**RE: Guardian Storage
Project #1002132**

The purpose of this letter is to explain the modifications that have been made to the Site Development Plan for Building Permit and Site Development Plan for Subdivision Amendment. The project was approved by the Environmental Planning Commission (EPC) on March 10, 2016.

Condition of Approval – 16EPC-40001 – March 10, 2016 – Zone Map Amendment

Conditions of Approval – 16EPC-40002 – March 10, 2016 – Site Development Plan for Building Permit

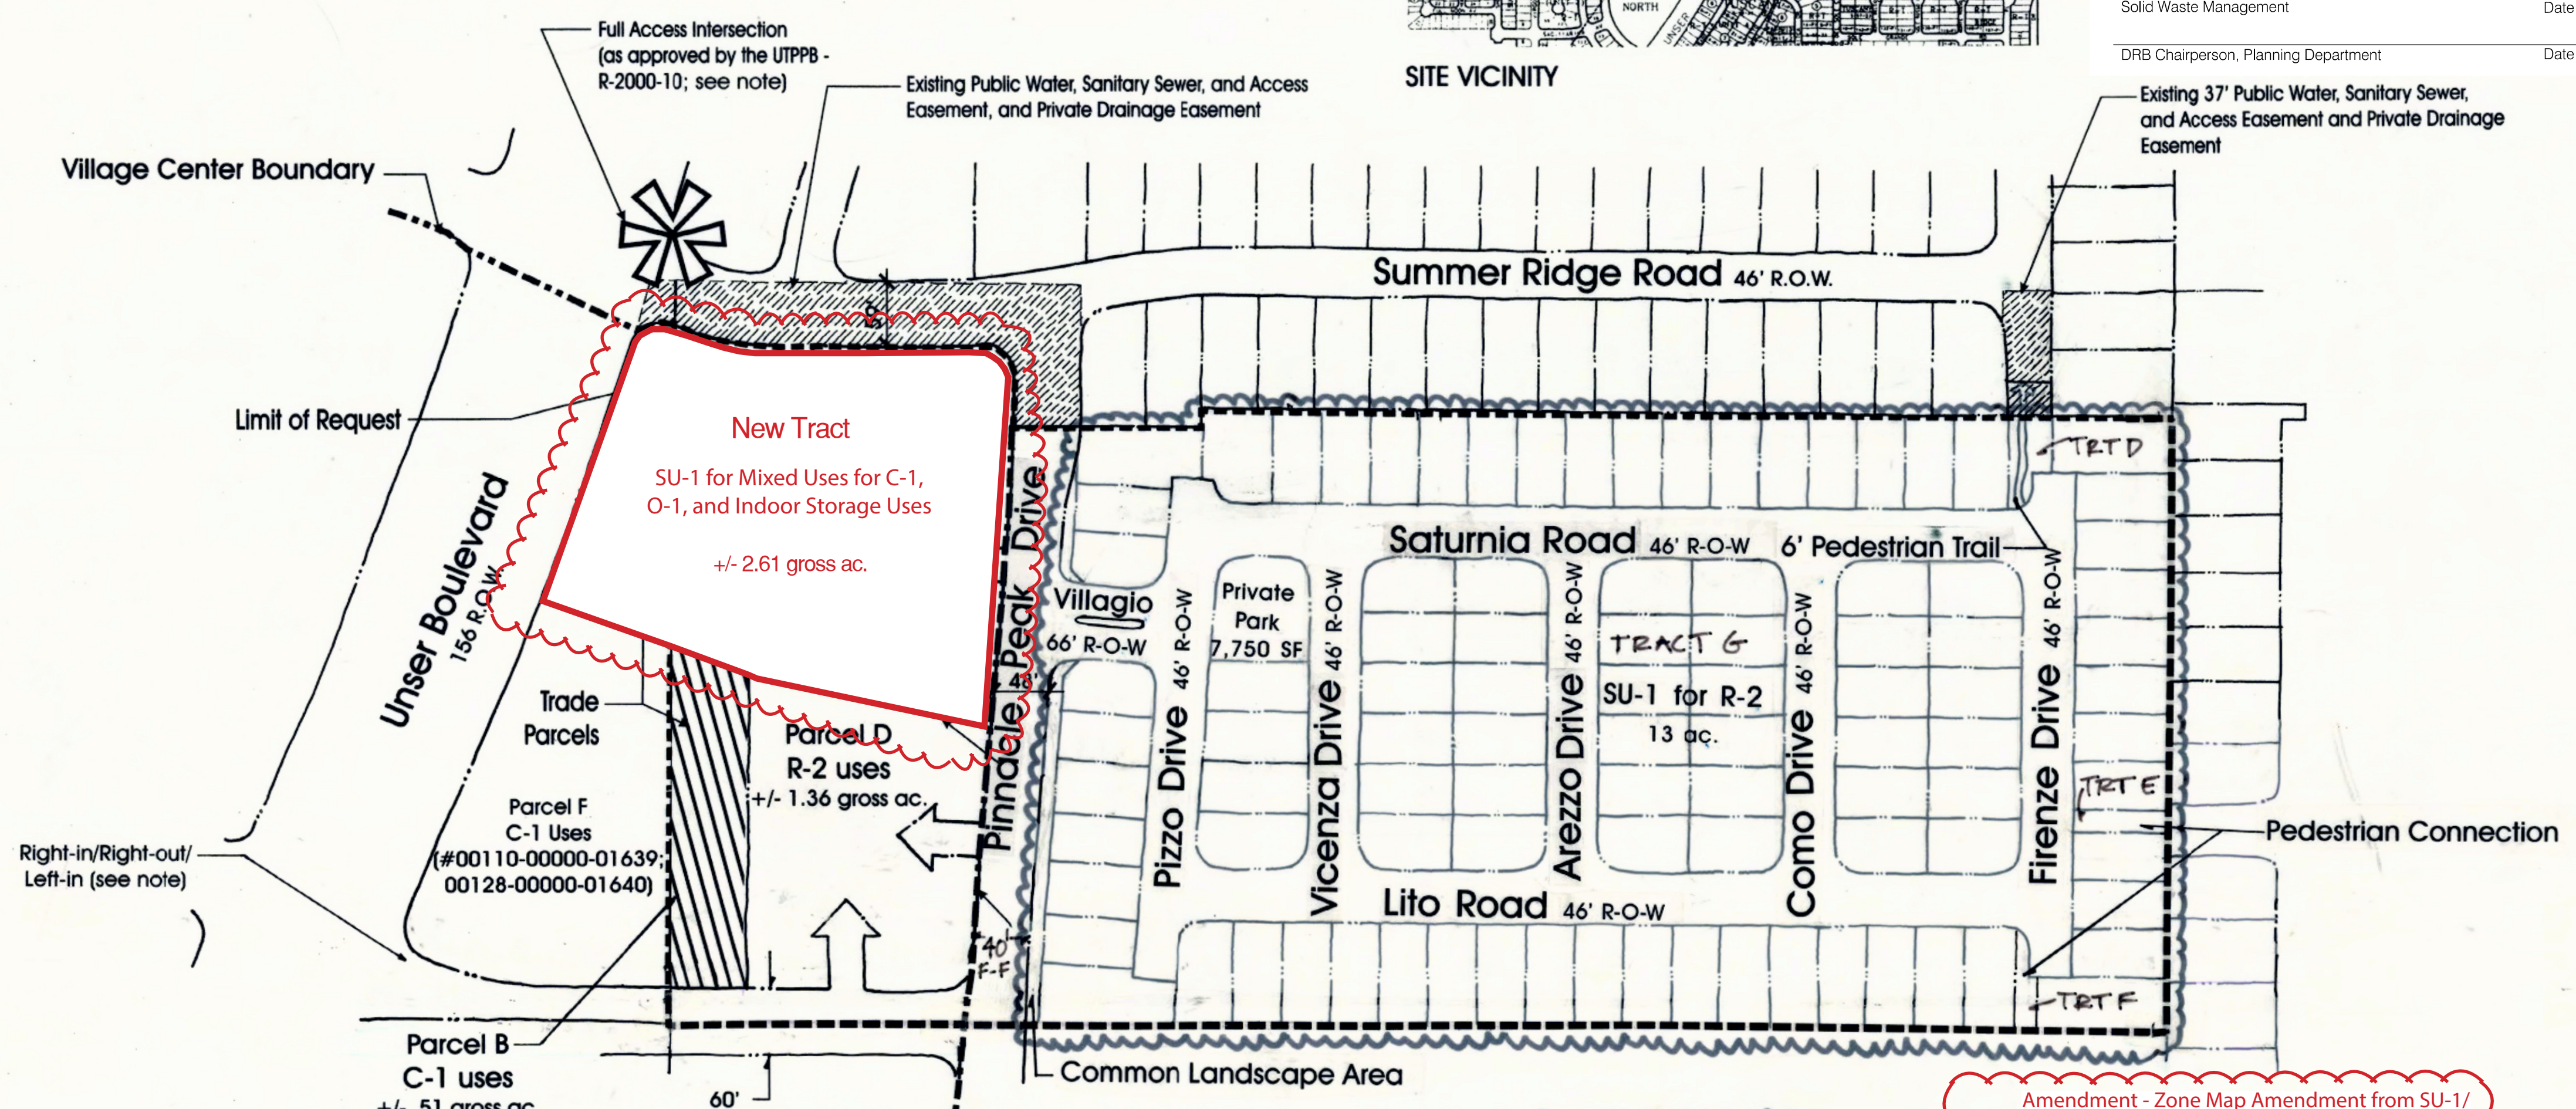
3. The zoning designation contained on Sheet 1 of 3 of the Unser / McMahon Village Center North Site Development Plan for Subdivision shall be revised to read "SU-1 for Mixed Uses for C-1, O-1, and Indoor Storage Uses." It currently reads, "SU-1/Mixed Uses for C-1, O-1, and Storage Uses."

Sheet 1 has been updated to read "SU-1 for Mixed Uses for C-1, O-1, and Indoor Storage Uses".
